NOTICE OF DECISION

Non-Material Amendment(s) Determination

Proposal: Main amendments to the proposal, following submission of the S278 application are as follows:

Location: Proposed Roundabout Access to Graven Hill and Wretchwick Green, London Road, Bicester

**A41 PIONEER ROUNDABOUT
DRAINAGE LAYOUT**

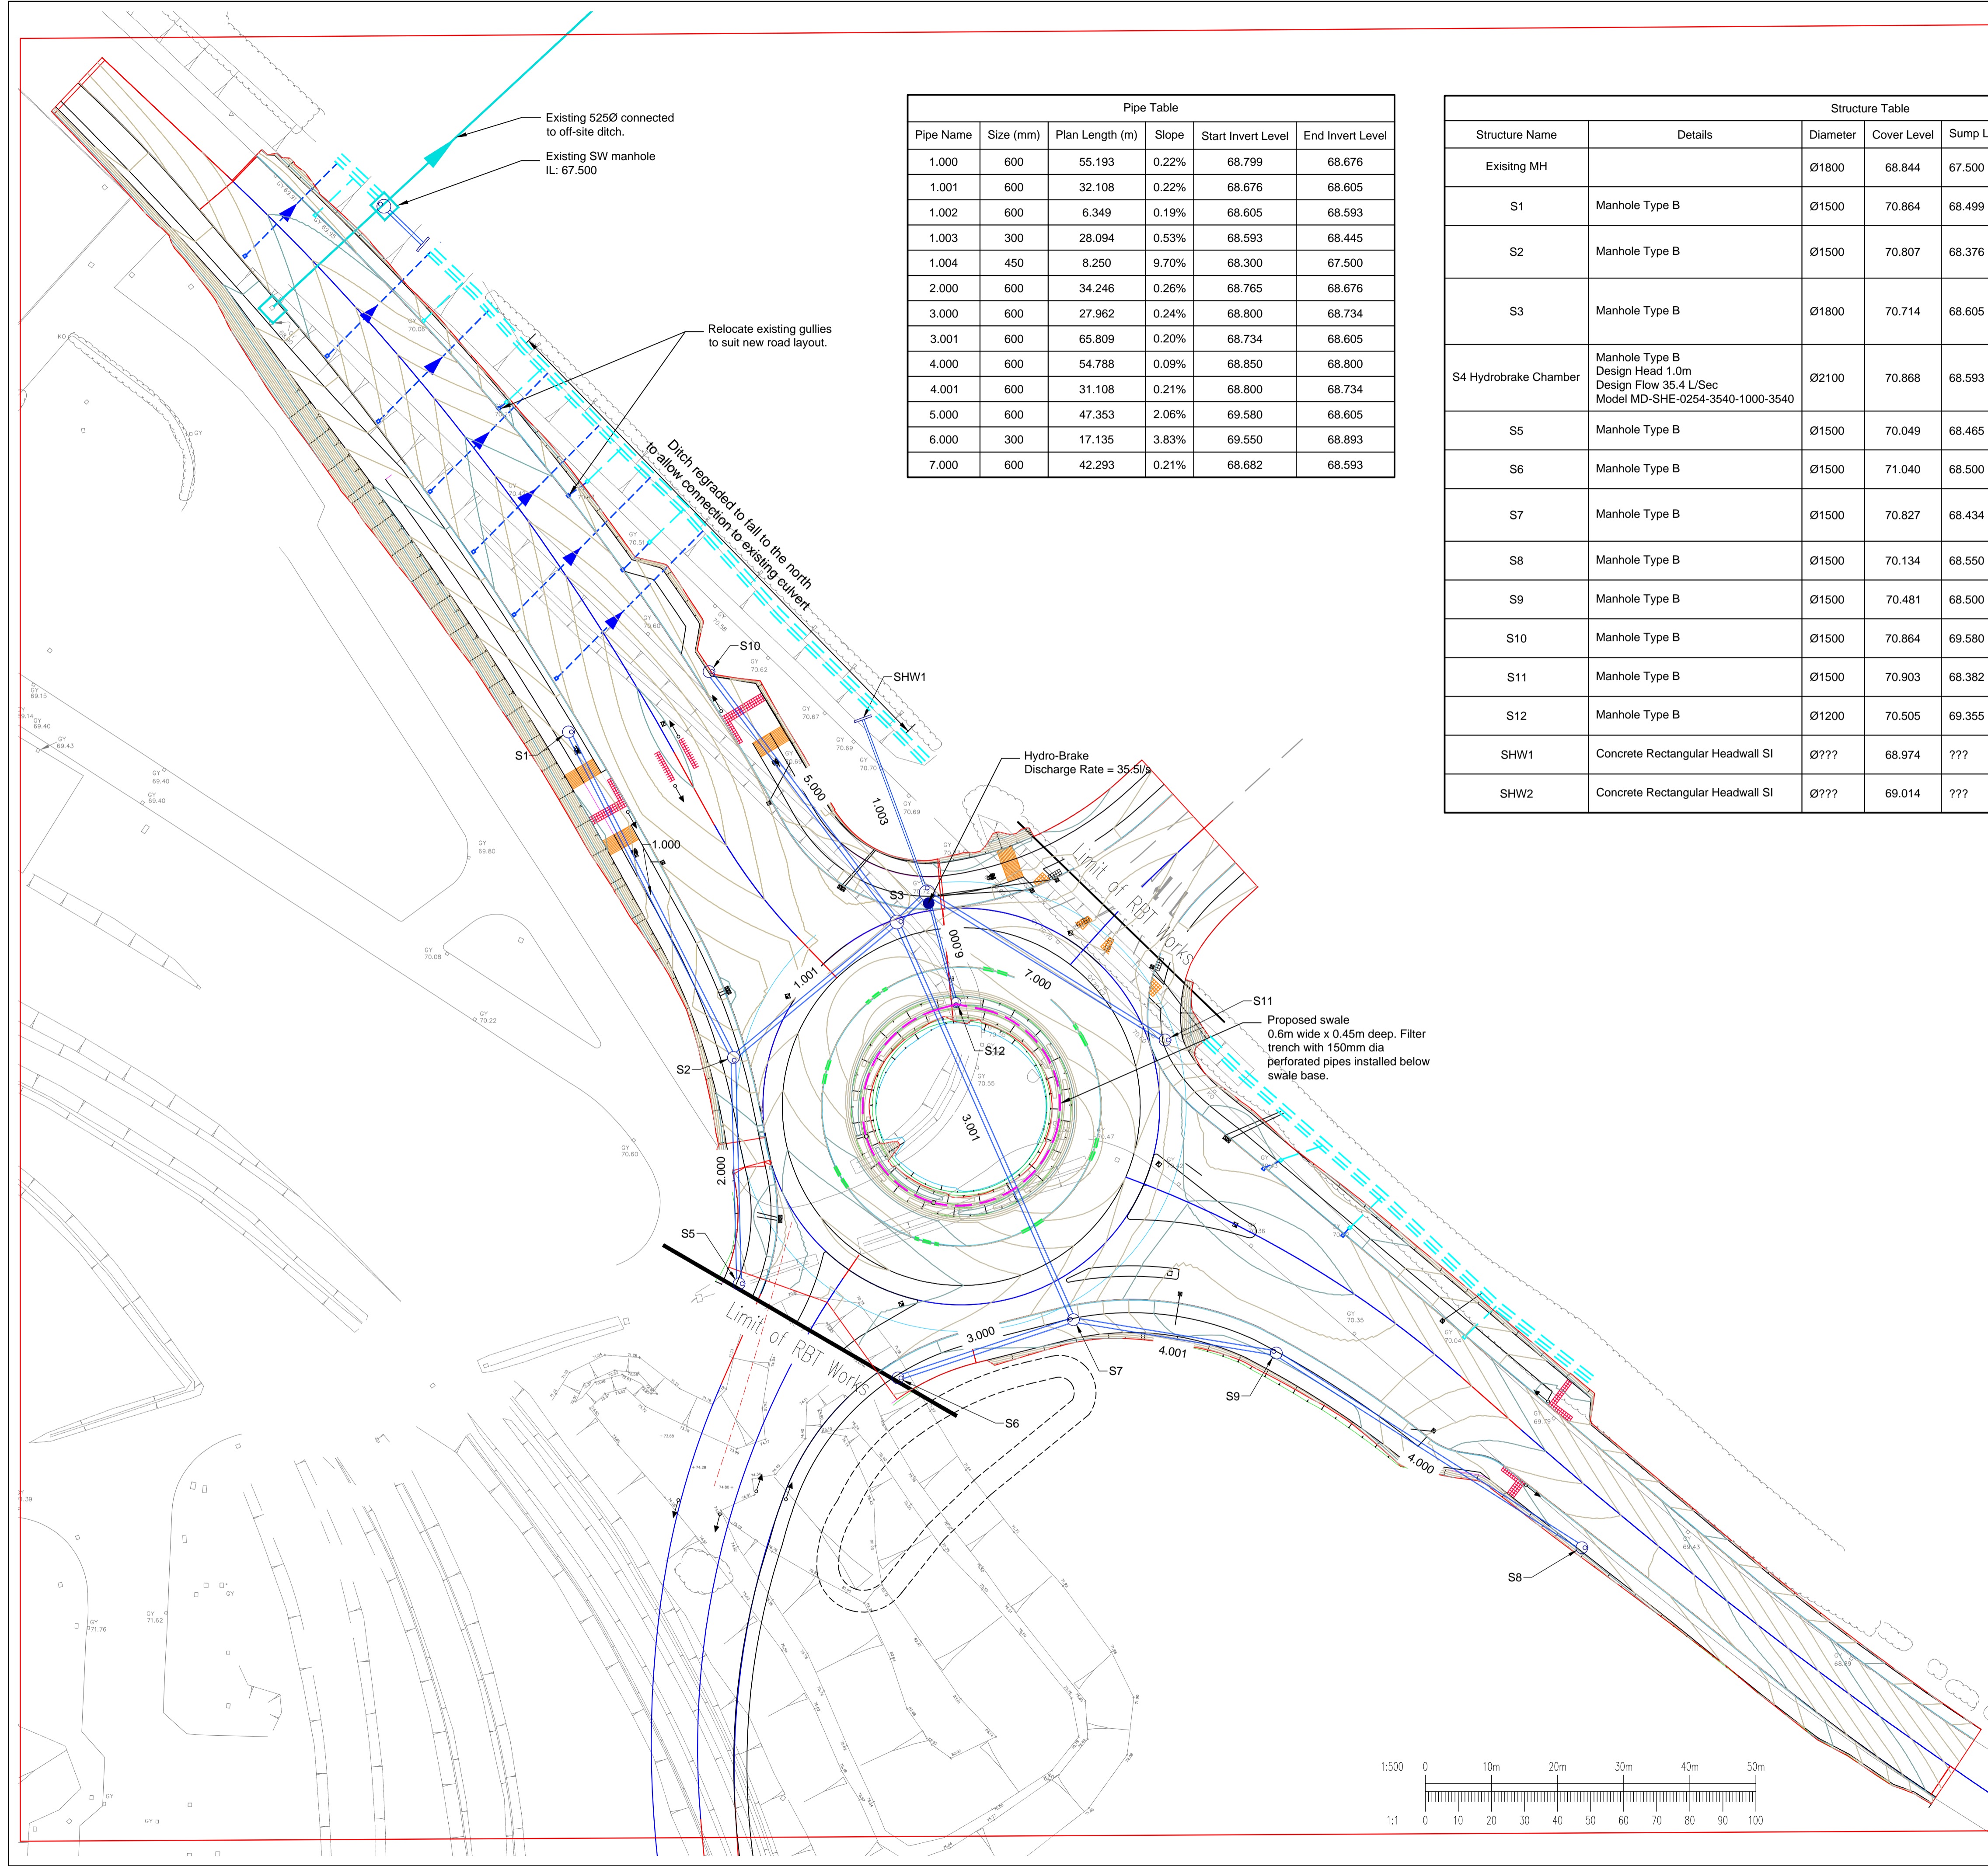
- Drainage: The previous drainage strategy included surface water attenuation within the central island of the roundabout. The attenuation has been removed and the proposals now include:

i. A swale within the central island to allow conveyance of surface water from the circulatory carriageway

ii. Oversized pipes (600mm diameter) to provide below ground storage in high rainfall events

iii. Provision of a hydrobrake to control surface water discharge to the ditch north of the A41 at agreed rates with Oxfordshire County Council (proposed as non-material amendments to 20/01830/F)
